**University of Sydney - Engineering and Technology Precinct - Mod 2 (SSD-8636-Mod-2)
Request for Additional Information**

Regarding Engineering and Technology Precinct Modification 2 (SSD-8636-Mod-2), the Department requests that you provide a response to Council's comments (attached), and particularly provide:

BON068: 1% AEP FLOOD LEVEL
AFFLUX PROPOSED - EXISTING

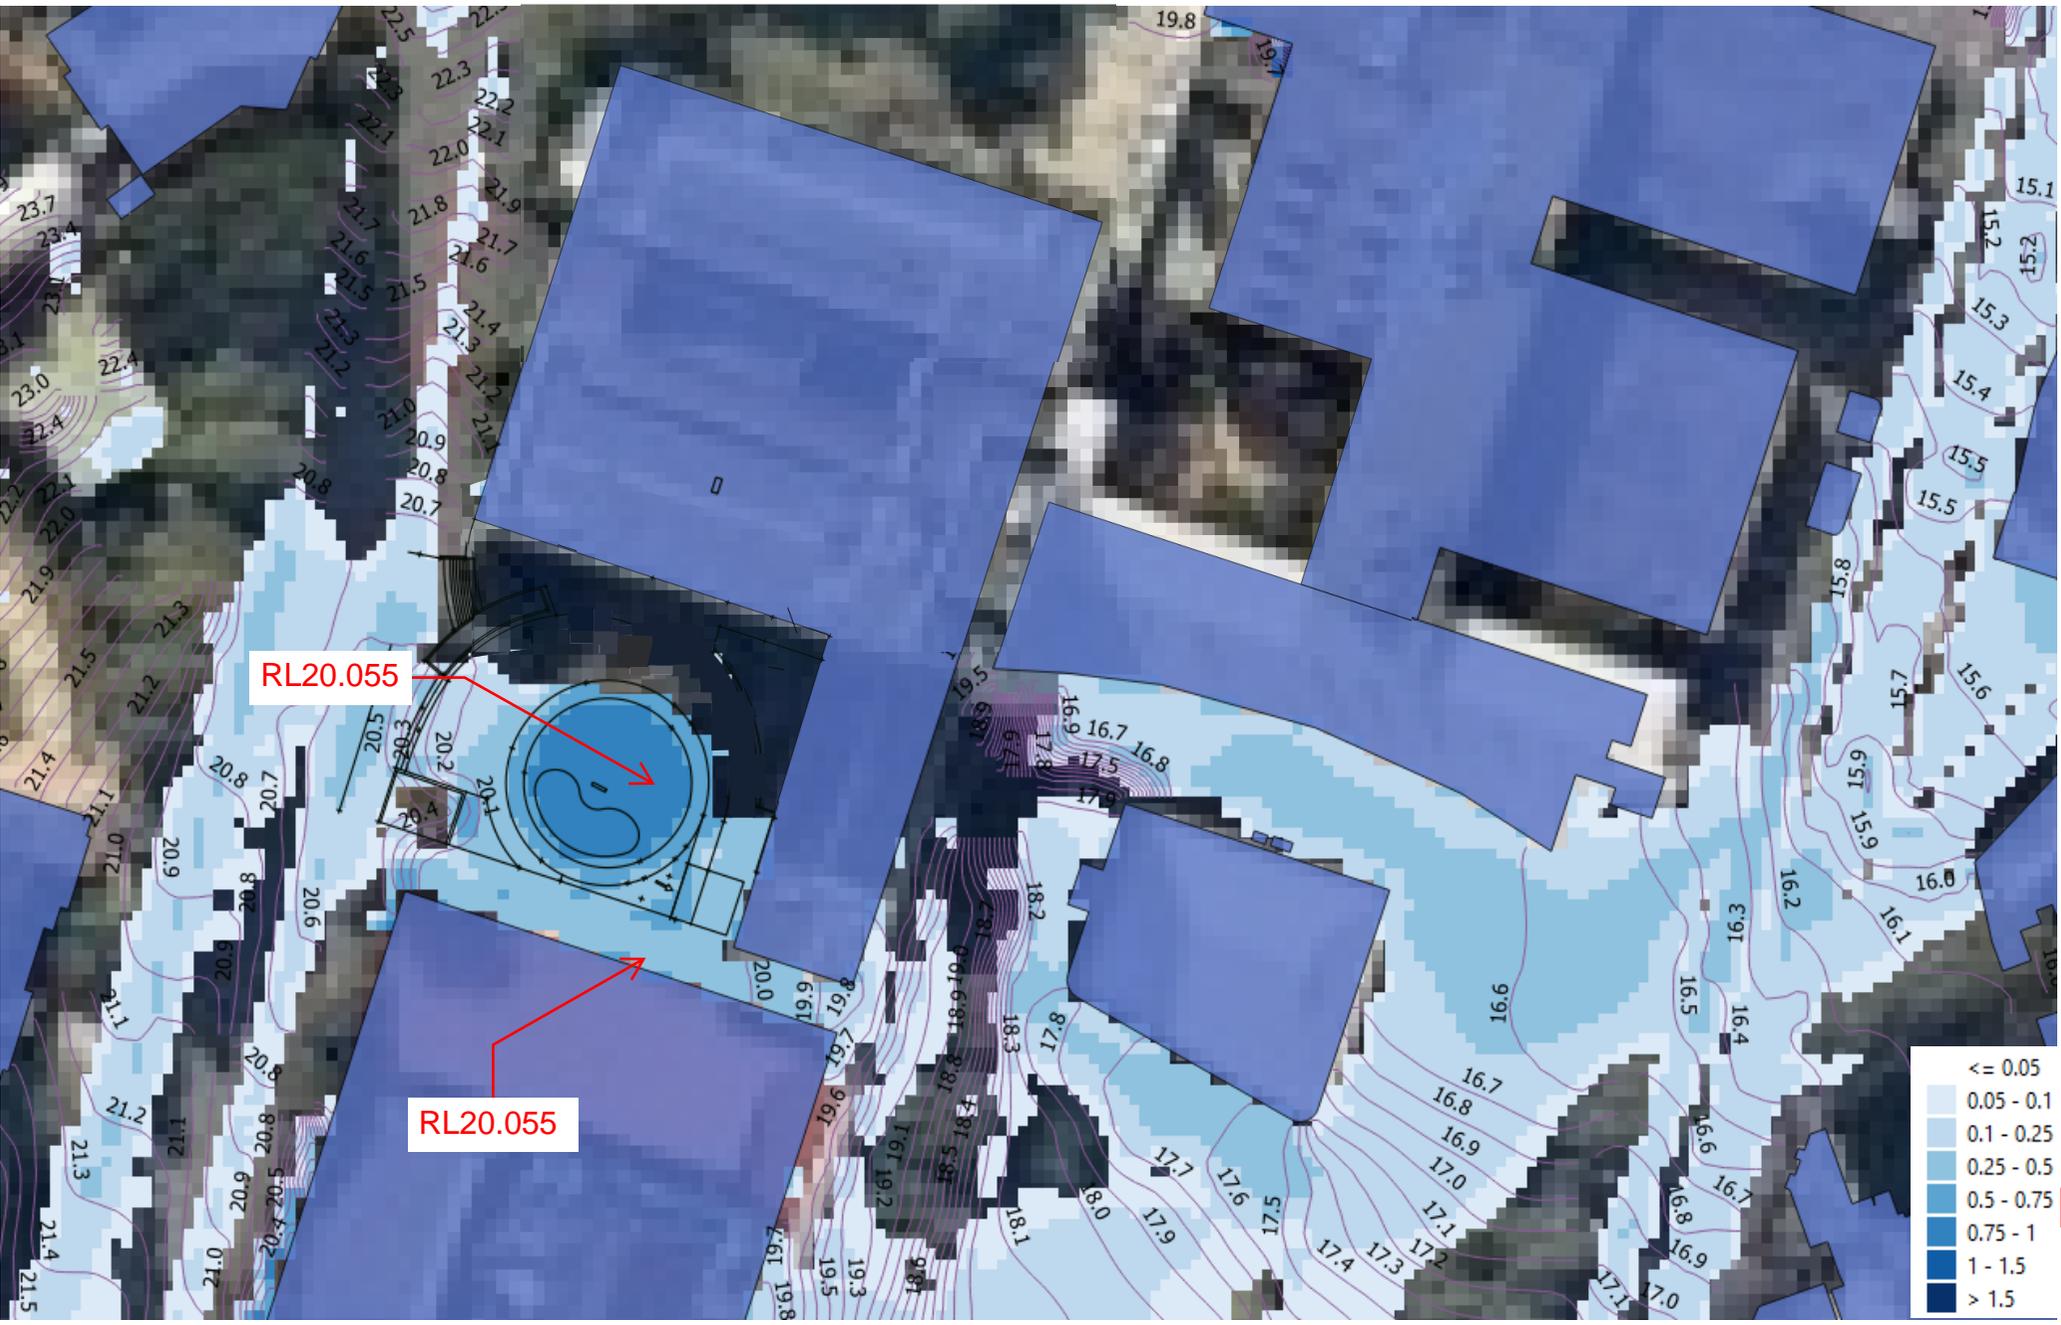
- further information concluding whether the alternative flooding mitigation proposed is capable of the same performance as the previously proposed basin.
- detailed plans and sections, levels and proposed edges demonstrating that the amended design is DDA compliant and fit for use.
- details of changes sought to the landscape layout of all plazas (i.e. comparison plans showing approved vs proposed northern, southern and eastern plazas including detail of the Basin D removal), changes to plant species and any changes to the total number of proposed trees across the subject site.
